**ADC Planning Consultation
Conservation/Design Officer Response**

Application Number	Y/65/17/HH
Address	Rumford Church Road Yapton BN18 0EW
Description	Buttressing & repair of failed flint wall. This application affects the setting of a Listed Building & the Character & Appearance of the Yapton (Main Road/Church Road) Conservation Area.
Case Officer	Mr R Temple
Date	5 th December 2017

Flint wall repair Proposed Plan and section

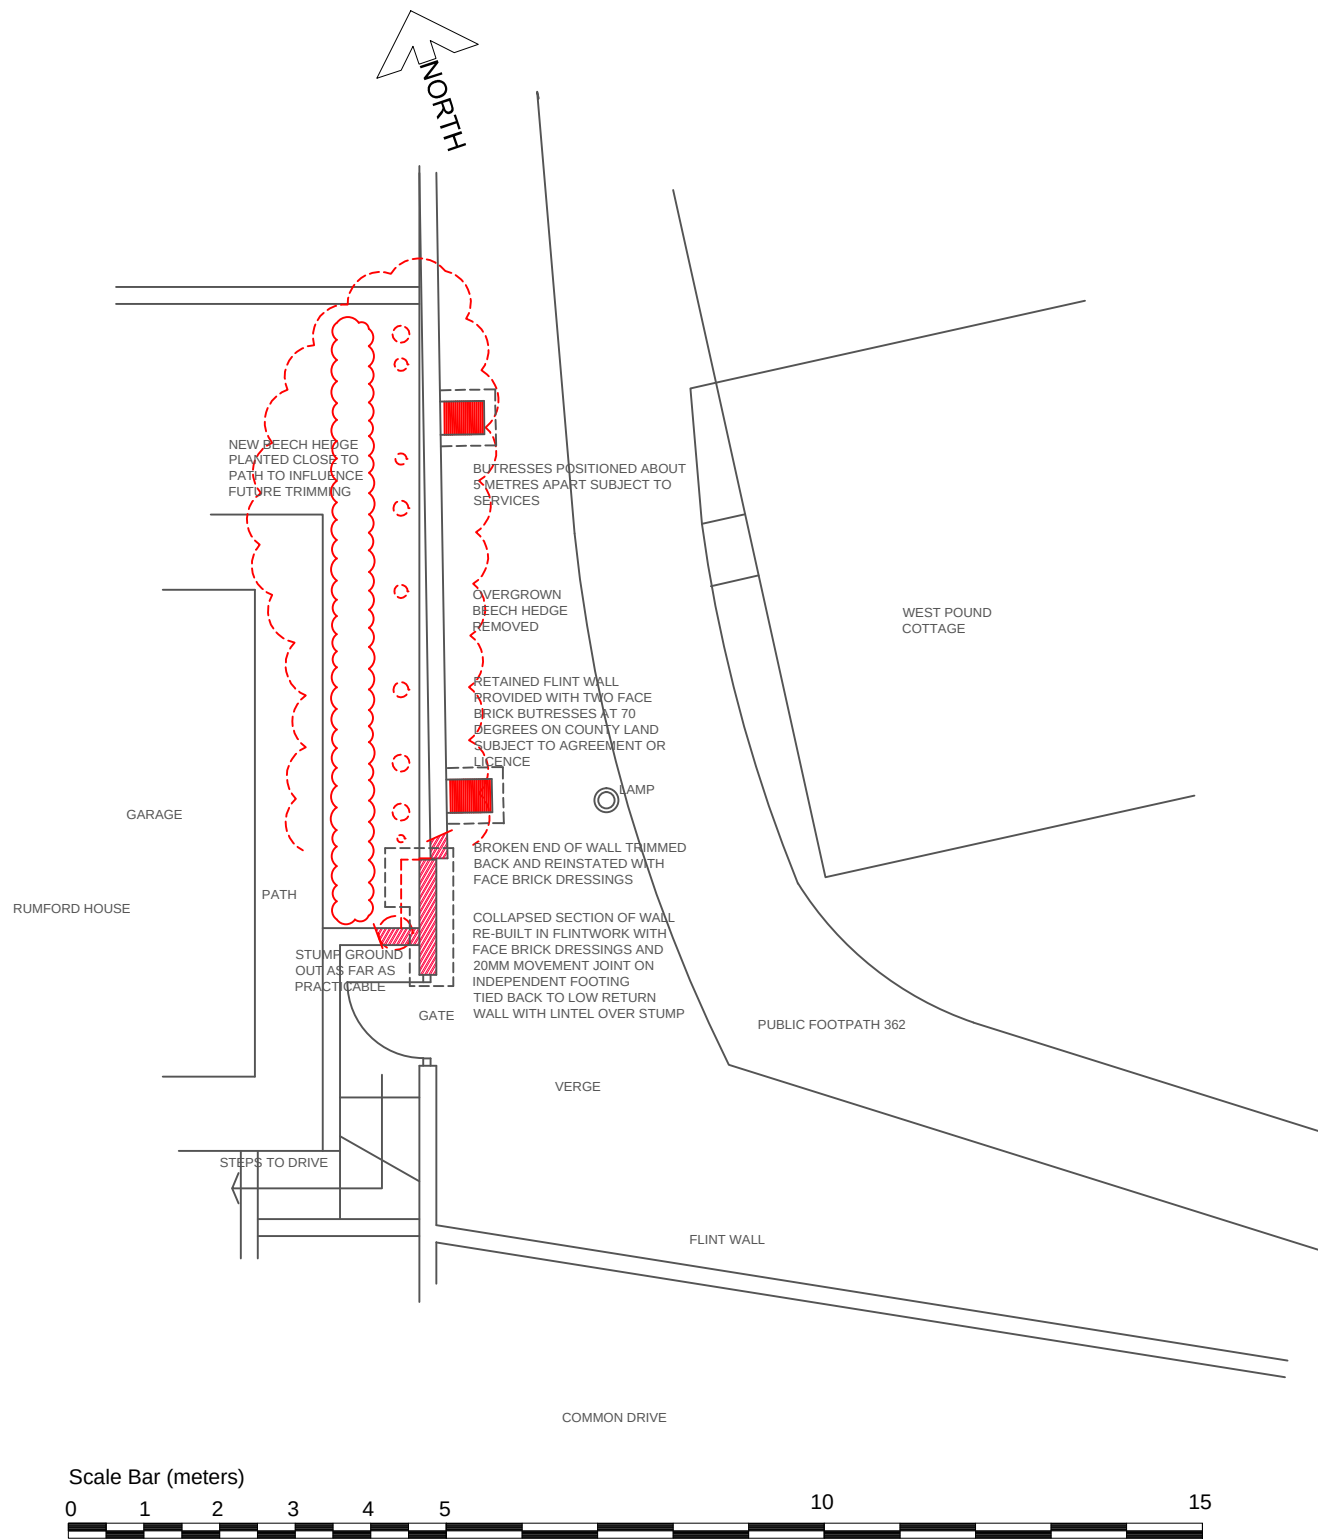
A section of the wall has collapsed, and submitted plans show the insertion of brick facings between existing and new flintwork, a movement joint, together with the insertion of 2no. brick buttresses in concrete footings.

While there is no objection to the repair of the collapsed section of wall, in suitable lime mortar, re-using the flint cobbles, it is not normal practice to insert a brick facing, nor piers, nor piers in a foundation as drawn. It is considered that the proposed is visually intrusive and upsets the visual harmony of the run of wall, and therefore I object to this application.

It is suggested that the collapsed section of wall is rebuilt using suitable lime mortar, with existing cobbles, capped to match existing. Should a structural survey suggest increased structural support is deemed necessary, the use of Helifix or a similar could be considered within the core of the wall. Any structural issues that are found to exist should be ascertained by a suitably qualified person, and be addressed accordingly via the usual process.
